A1 in Northumberland: Morpeth to Ellingham

Scheme Number: TR010059

Applicant's Comments on Responses to Written Questions – Appendix A - Public Rights of Way Response

Version	Date	Status of Version
Rev 0	January 2021	Examination Deadline 2

Drawing Title: RIGHTS OF WAY AND ACCESS PLANS REGULATIONS 5(2)(k) & 5(2)(o) SHEET 02 OF 19

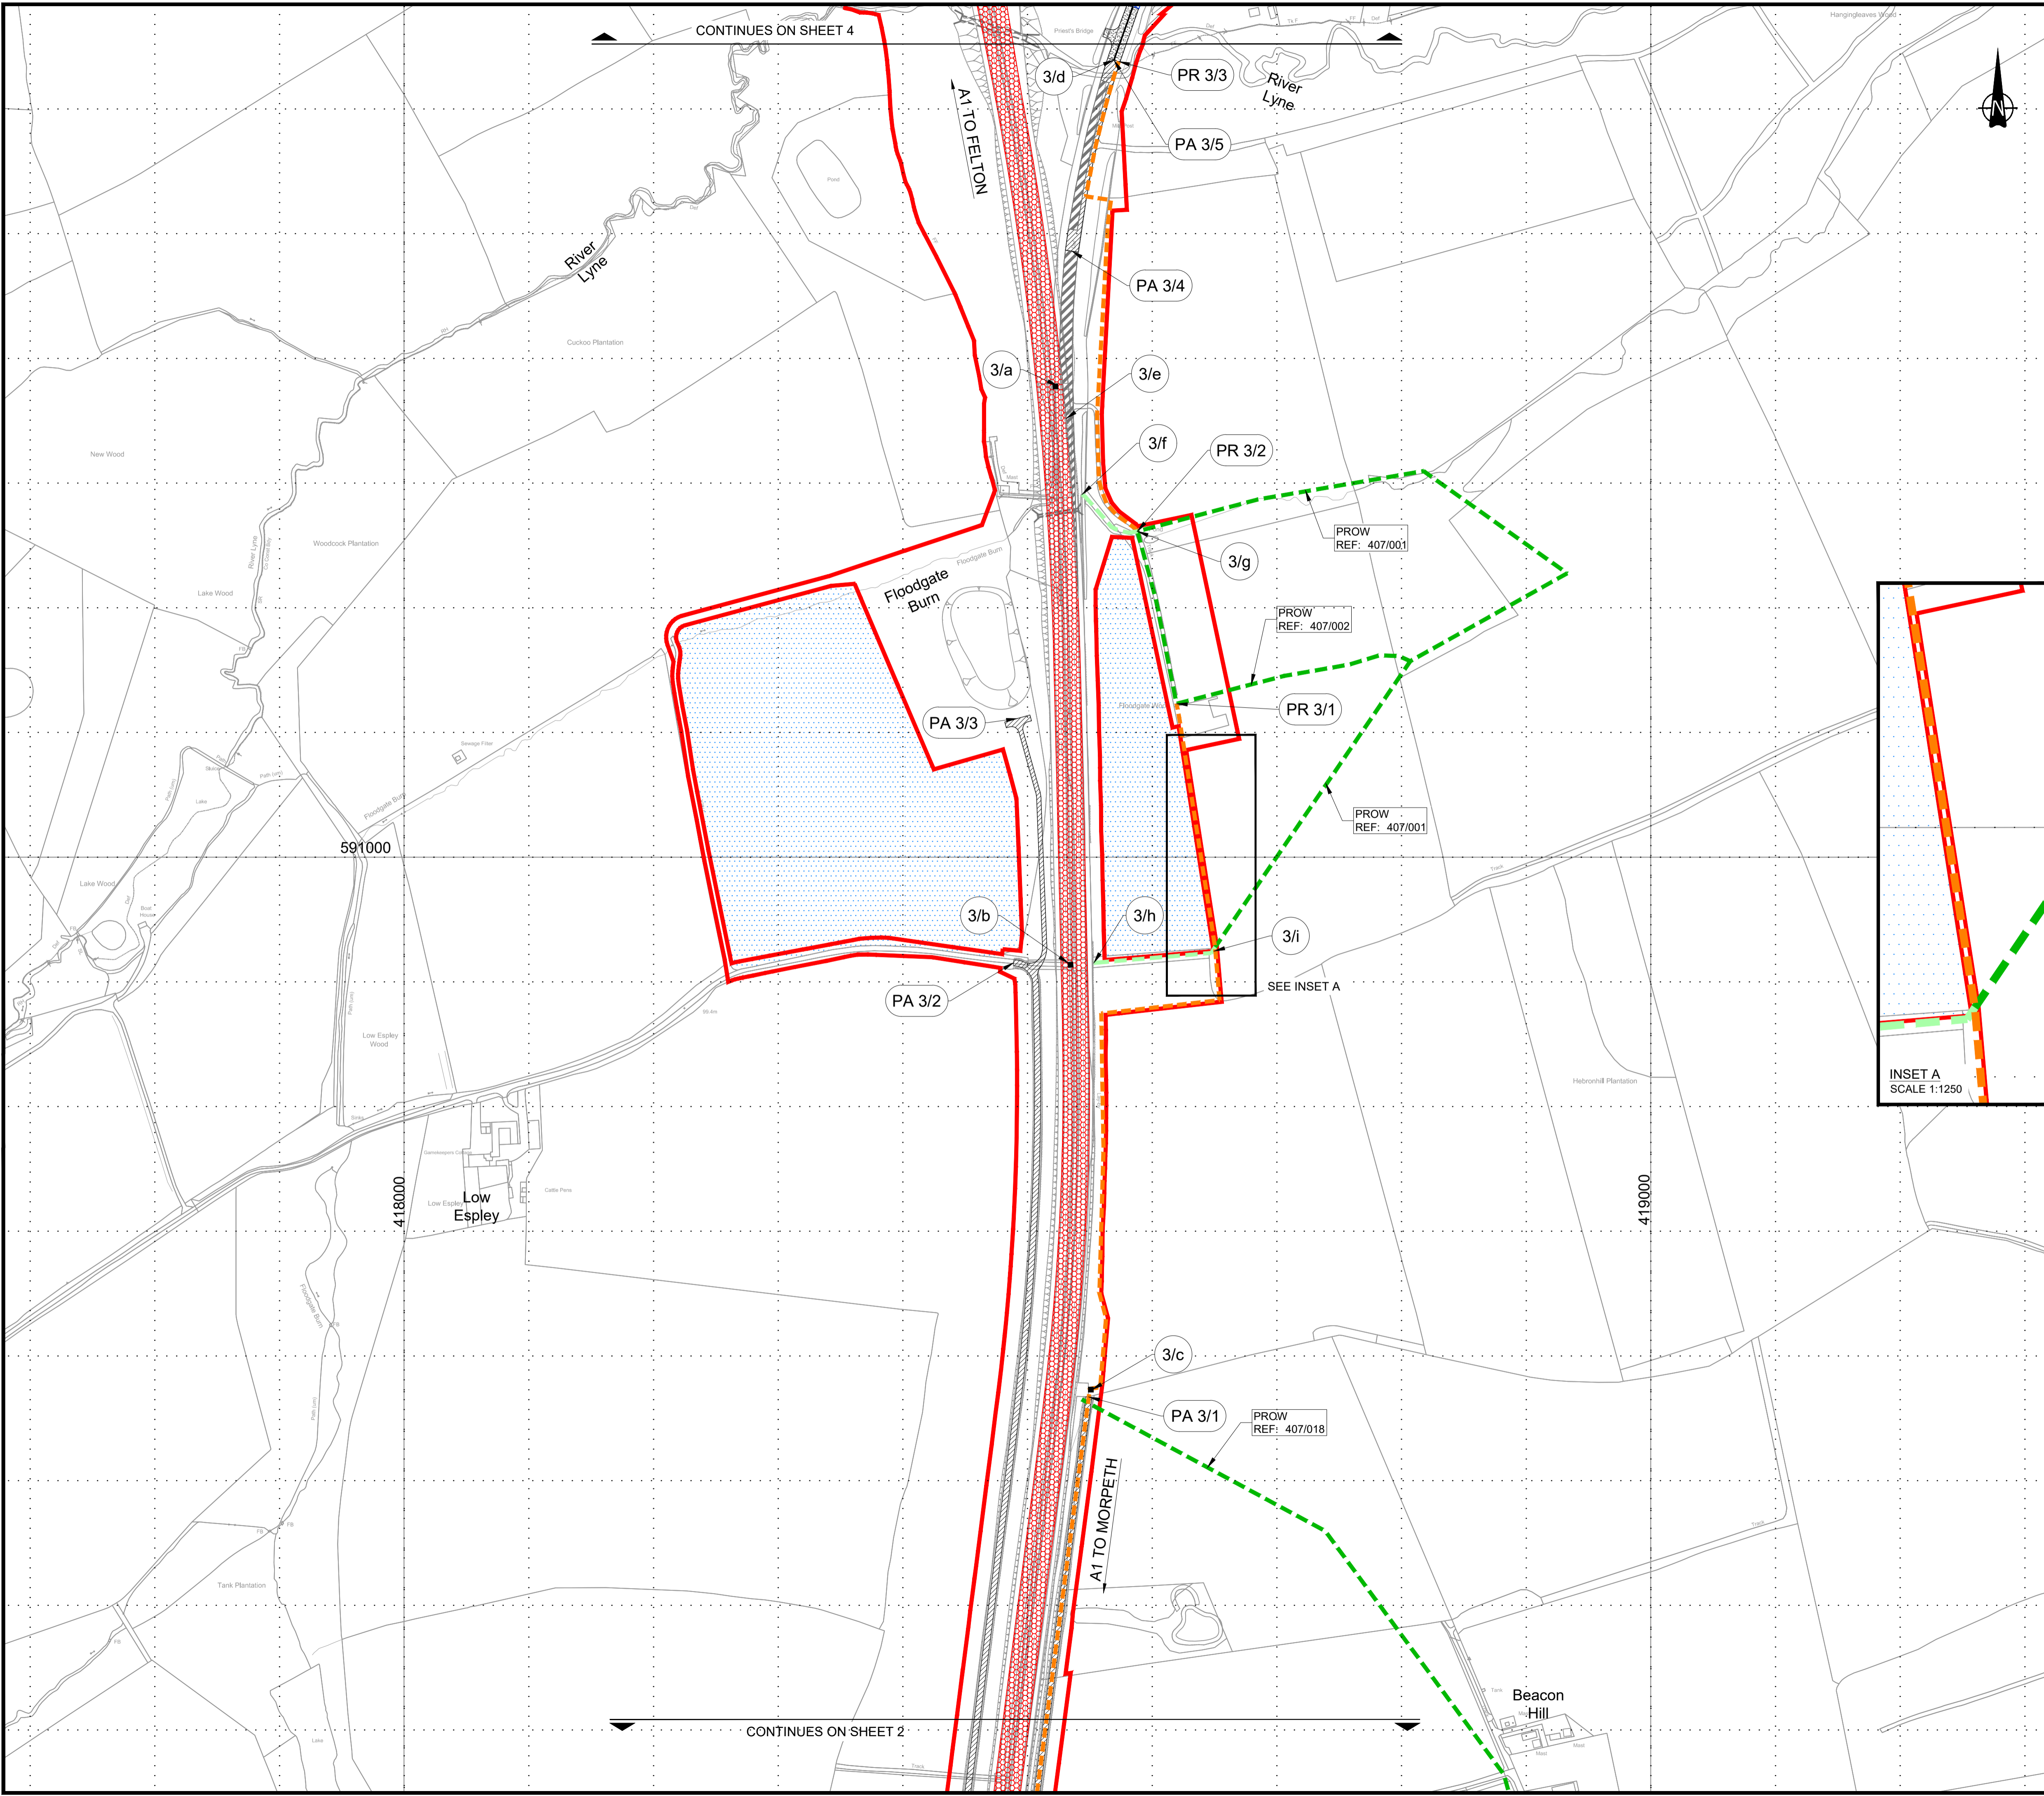
Street to be stopped up	Extent of stopping up	New Highway to be substituted	NCC Comments	Applicant's Response
The permanent stopping up and removal of the existing unregistered street.	From point 418195E, 589709N to 418370E, 589720N (measuring approximately 174.5m in length) shown as between 2/h and 2/l on Sheet 2 of the rights of way and access plans.	Highway to be removed and replaced by New Side Road in terms of Work Number 8b, Sheet 2 of the works plans.	C140	The Applicant has updated Schedule 4 Part 1 in the Draft DCO [APP-014] to include the road number (C140) of this adopted highway.
The permanent stopping up and removal of the existing A1 carriageway.	From existing A1 418531E, 591352N to 418536E, 591486N starting at 3/d on Sheet (measuring approximately in length), Sheet 3 of the rights of way and access plans and running in a southwards direction for a distance of approximately 134.4m.	Detrunked A1 will be replaced by the new A1 dual carriageway shown on Sheets 1 to 17 of the rights of way and access plans.	A1	The Applicant has updated the reference to A1 in Schedule 4 Part 1 in the Draft DCO [APP-014]. Reference labels have been amended to reflect the rights of way and access plans [APP-009].

Drawing Title: RIGHTS OF WAY AND ACCESS PLANS REGULATIONS 5(2)(k) & 5(2)(o) SHEET 04 OF 19

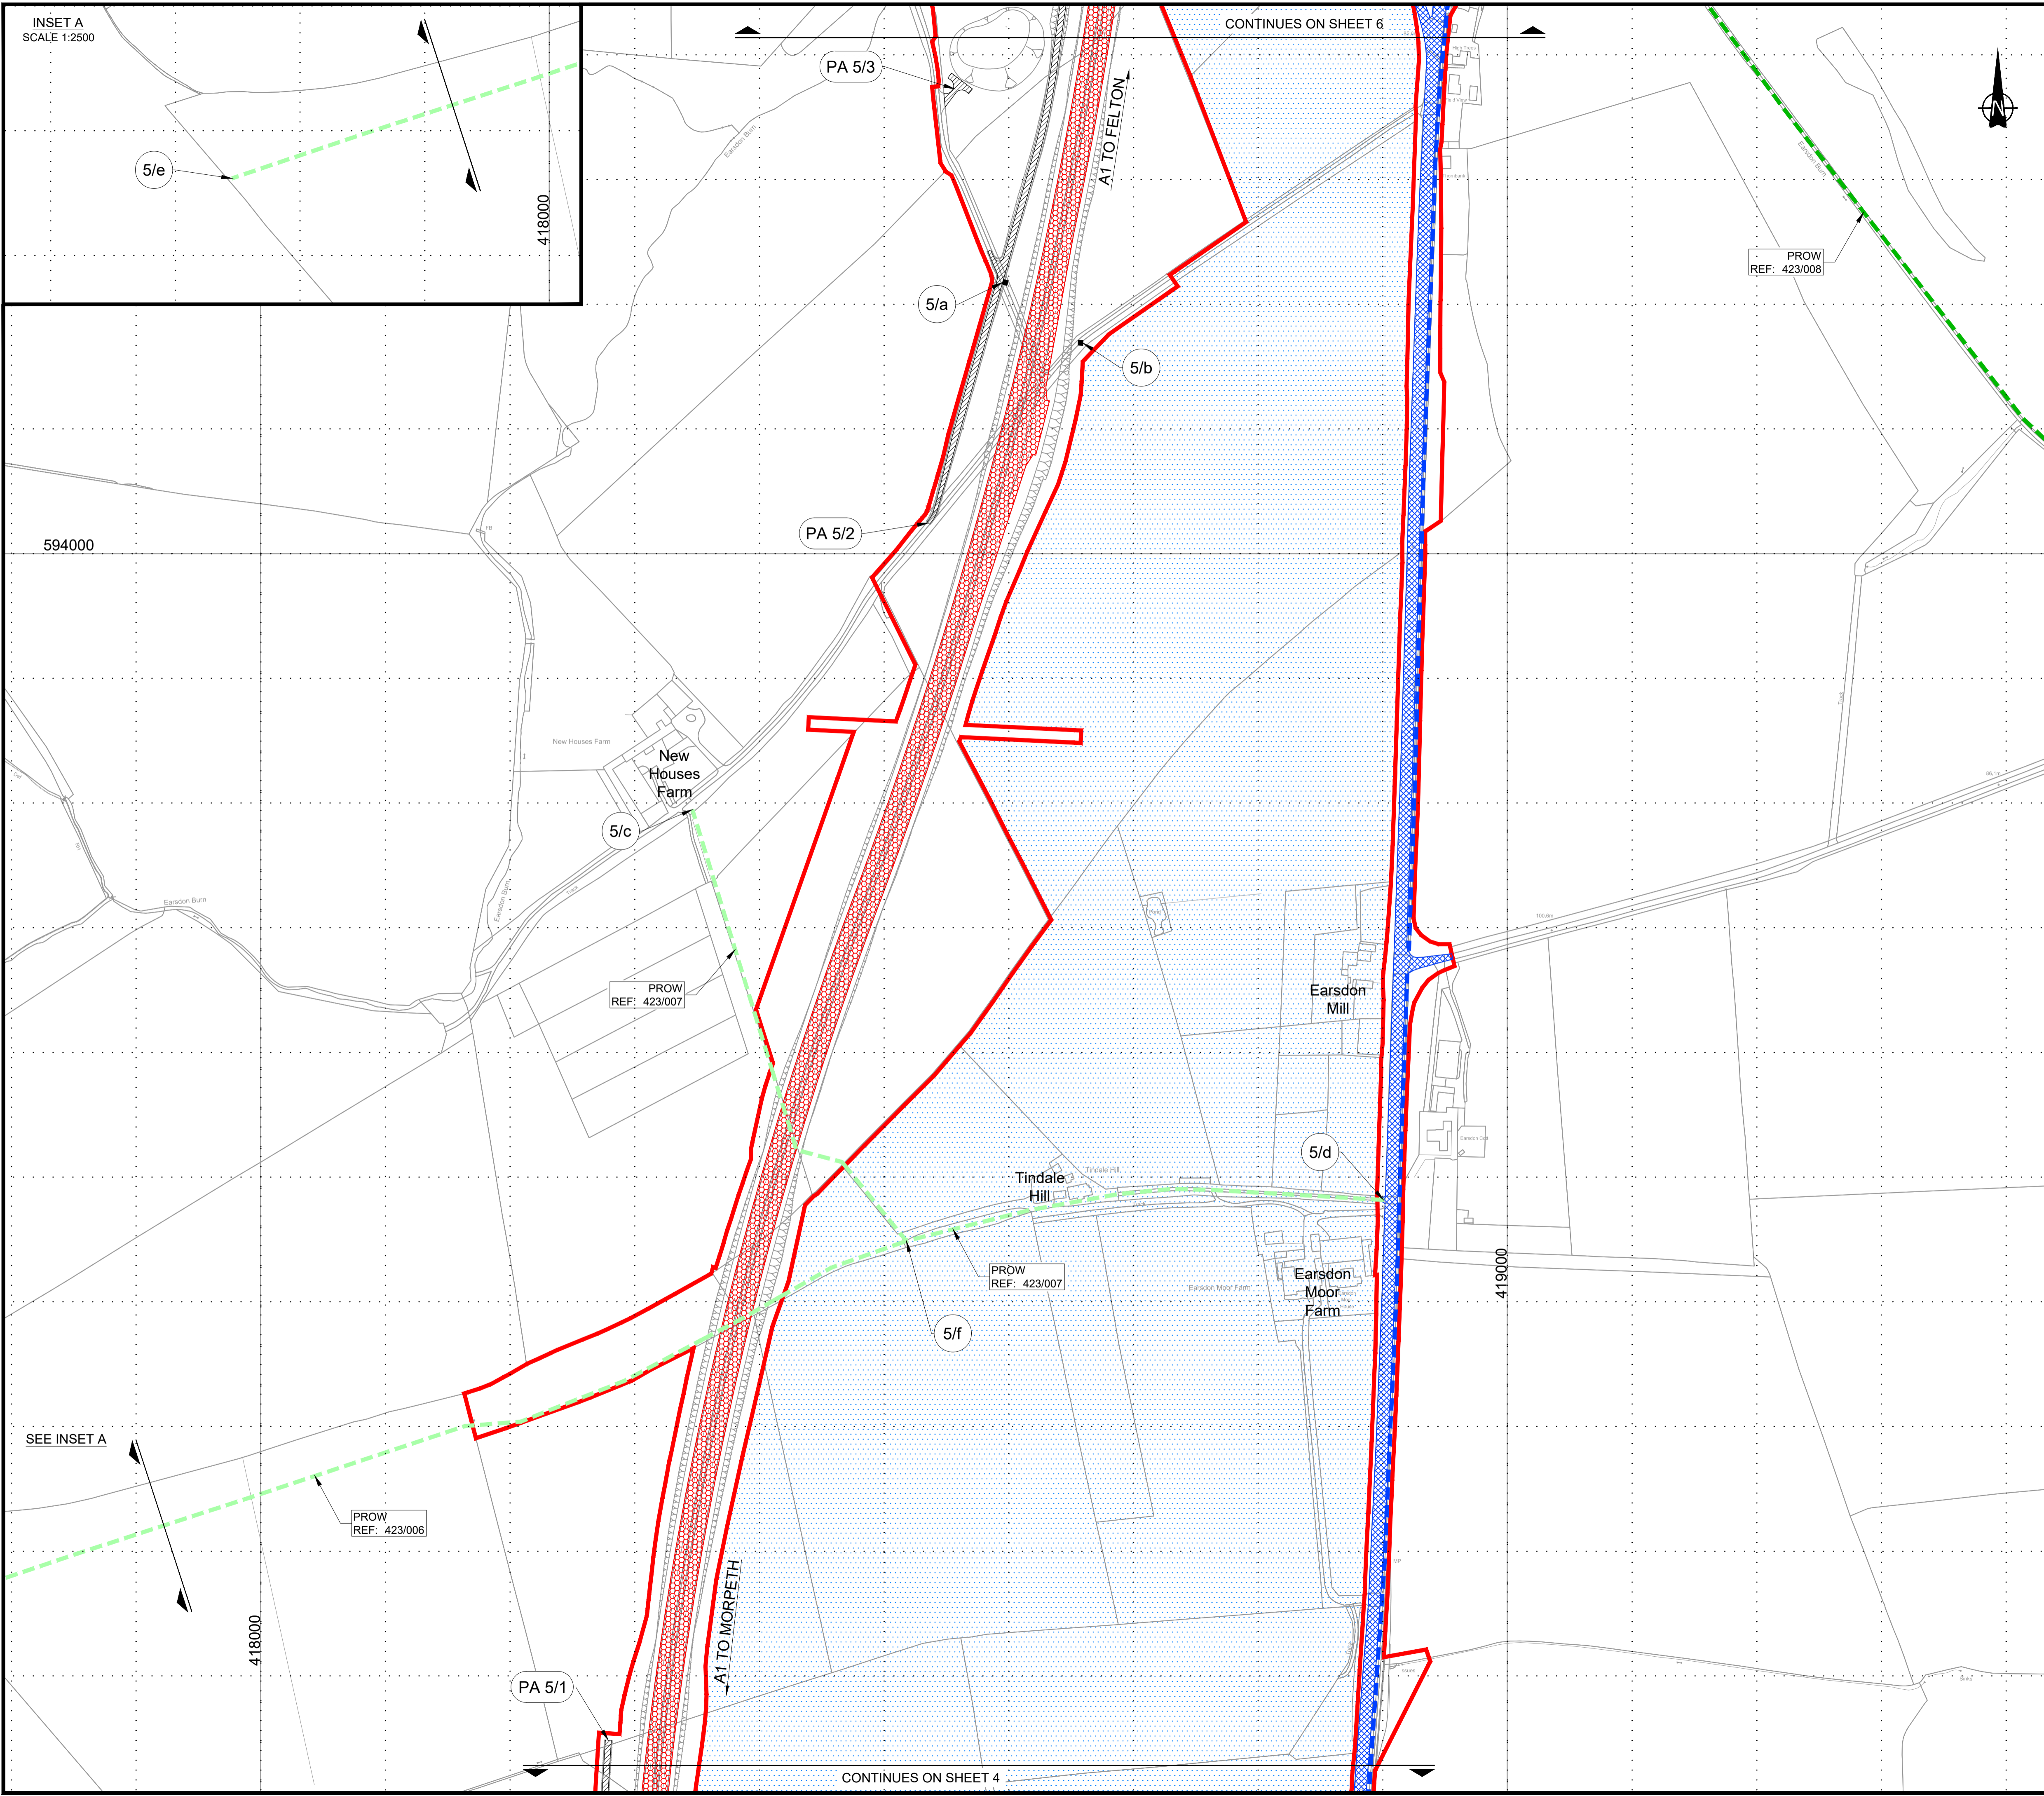
The permanent stopping up and removal of the existing street between Fenrother Lane (West) and Fenrother Lane (East) carriageway.	Including access points 418218E, 592538N to 418398E, 592595N (measuring approximately 188.3m in length) between points 4/k and 4/l on Sheet 4 of the rights of way and access plans.	Removal will be replaced by the Fenrother Junction, between 4/k and 4/l, Sheet 4, rights of way and access plans.	C139	The Applicant has updated Schedule 4 Part 1 in the Draft DCO [APP-014] to include the road number (C139) of this adopted highway.
The permanent stopping up of part of Fenrother Lane (East) (east and west).	Stopping up will include points 418676E, 592558N to 418811E, 592533N of existing road, (measuring approximately 137.6 m in length, combined) between points 4/g and 4/h on Sheet 4 of the rights of way and access plans.	Replaced by new tie in between the detrunked A1 and Fenrother Lane (East) by new carriageway 4/B, between 4/g and 4/h, Sheet 4 of the rights of way and access plans.	C139	The Applicant has updated Schedule 4 Part 1 in the Draft DCO [APP-014] to include the road number (C139) of this adopted highway.

The permanent stopping up of existing A1 north/south between Tritlington Church of England First	Stopping up will include points 418851E, 592675N and 418830E, 592511N of existing road, starting at	Replaced by new tie in between the detrunked A1 and Fenrother Lane (East) by new carriageway 4/B,	A1	The Applicant has updated the reference to A1 in Schedule 4 Part 1 in the Draft DCO [APP-014]. Reference labels have been amended to reflect the rights of way and access plans [APP-009].
School and Welbeck House.	4/c on the Sheet 4 of the rights of way and access plans and running in a southwards direction for a distance of approximately 164.6m.	Sheet 4 of the rights of way and access plans.

(1) Public right of way to be stopped up	(2) Extent of stopping up	(3) New highway to be substituted	Applicant's Response
		PR 4/2 and PR 4/1 and between points PR 4/3 and PR 4/4 on Sheet 4 of the rights of way and access plans.	substituted have been provided to a greater degree of accuracy.
Permanent stopping up of existing Footpath 423/013, between Causey Park Road and The Oak Inn.	From point 418736E, 594782N to 418344E, 595115N (578m in length) between points 6/d and 6/e on Sheet 6 of the rights of way and access plans.	A 2 metre wide public footpath, from point 418344E, 595115N on existing Footpath 423/013 in a general northerly direction, parallel to the proposed A1, for a distance of 520m, to point 418825E, 595241N on the U6017 road (Causey Park Road) as shown between points PR 6/1 and PR 6/2, on Sheet 6 of the rights of way and access plans.	The Applicant has updated Schedule 4 Part 2 in the Draft DCO [APP-014] to reflect NCC's proposed amendments to the description of the PRoW to be stopped up and details of the new highway to be substituted, with the exception of the proposed inclusion of the footpath width. The widths of the proposed public rights of way have not been included in the Schedule due to potential on-site variances but will be specified in the Public Rights of Way Management Plan which forms part of the CEMP. The CEMP requires to be approved by the Secretary of State and subject to consultation with NCC. The coordinates of the start/end points and the length of new highway to be substituted have been provided to a greater degree of accuracy.

Add points PR 4/7 and PR 4/8 at locations of PA 4/6 and 4/c south of Welbeck House.	The existing footway will continue to be within public land; therefore, the Applicant considers that the establishment of a public right of way will not be required.
Plan 5	
Change footpath label at Tindale Hill from 423/006 to be 423/007. Path 7 goes from New Houses to Earsdon Moor.	The Applicant acknowledges that the first section of the PRoW prior to the split for 423/006 and 423/007 is in fact 423/007 for this shared section. The Applicant has updated the Rights of Way and Access Plans [APP-009] with the correct label reference.
Add point 5/f at junction of Footpaths 423/006 and 423/007, west of Tindale Hill.	The Applicant has updated the Rights of Way and Access Plans [APP-009] to include the new reference label "5/f".
Plan 6	
Relabel the footpath between points 6/e and PA 6/1 to be part of 423/013. Path 423/017 does exist, but it is the short path between layby and A1, south of The Oak Inn.	The Applicant acknowledges that the section of existing PRoW between Causey Park Bridge and the new A1 is actually 423/013, not 423/017 and that the section of existing PRoW between the A1 to be de-trunked and Causey Park Bridge side road is separately designated as 423/017. The Applicant has updated the Rights of Way and Access Plans [APP-009] with the correct label reference.
